KITTITAS COUNTY

DEPARTMENT OF PUBLIC WORKS

MEMORANDUM

SUBJECT: Mitchell Short Plat SP-16-0001

**MITCHELL SHORT PLAT
PART OF SECTION 31, T. 20 N., R. 17 E., W.M.
KITITIAS COUNTY, WASHINGTON**

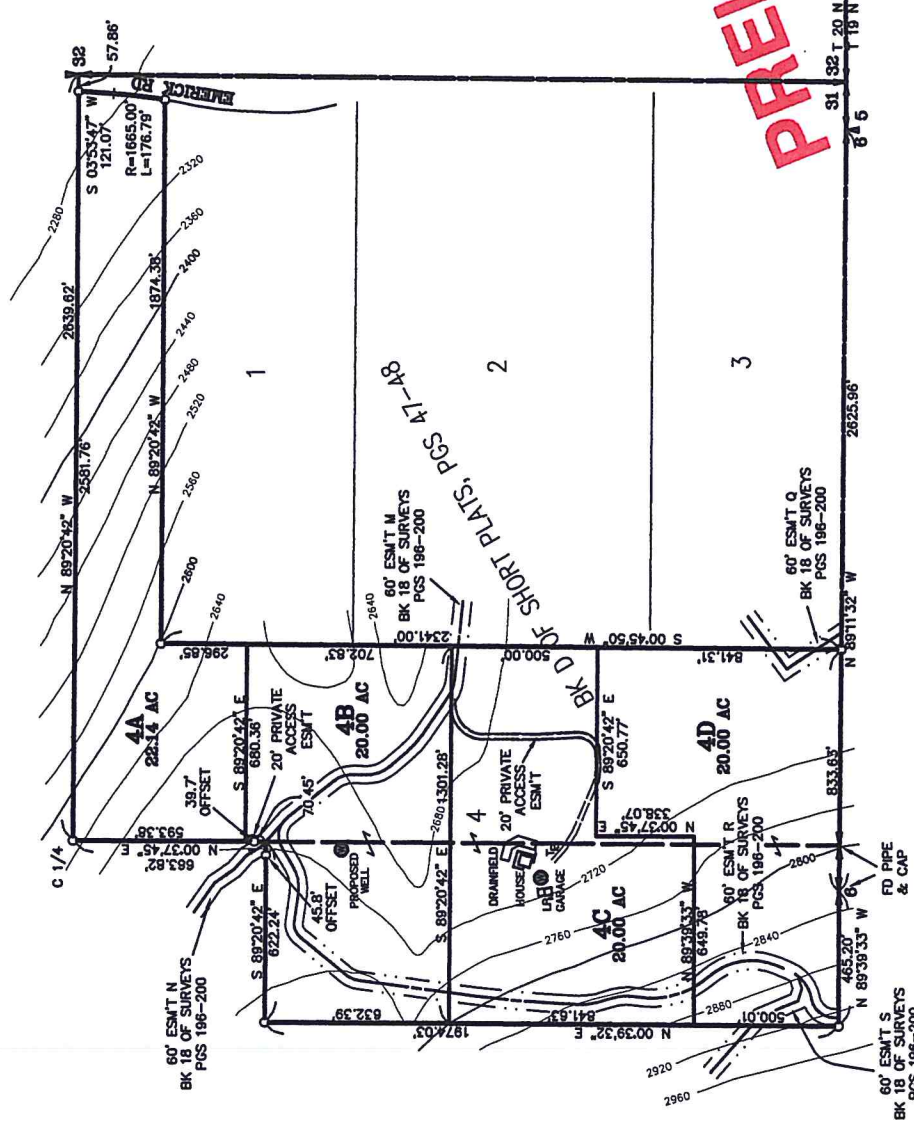
1. Transportation Concurrency: Applicant needs to submit their application for Transportation Concurrency to the Department of Public Works.
2. 20' Private Access Easement: The intent of this access easement needs to be specific to lot 4C. Lot 4D will need to come directly off of the 60' Easement Q of Bk 18 pgs 196-200. If the applicant chooses to make the private access easement a shared easement, the easement will need to meet the joint use access requirements.

5. Private Road Improvements: Access from Emerick Road shall be constructed as a Low-Density Private Road. See Table 4-4, current Kittitas County Road Standards, 12/15/15 edition.

- a. Access easements shall be a minimum of 60' wide. The roadway shall have a minimum width of 20', with 1' shoulders, for a total width of 22'.
 - b. Minimum centerline radius will be 60'.

- c. The surface requirement is for a minimum gravel surface depth of 6".
 - d. Maximum grade is 10%.

- g. 20' Private Access Easement: The intent of this access easement needs to be specific for lot 4C. Lot 4D will need to come directly off of the 60' Easement Q of Bk 18 pgs 196-200. If the applicant chooses to make the private access easement a shared easement, the easement will need to meet the joint use access requirements Any further subdivision or lots to be served by proposed access may result in further access requirements.
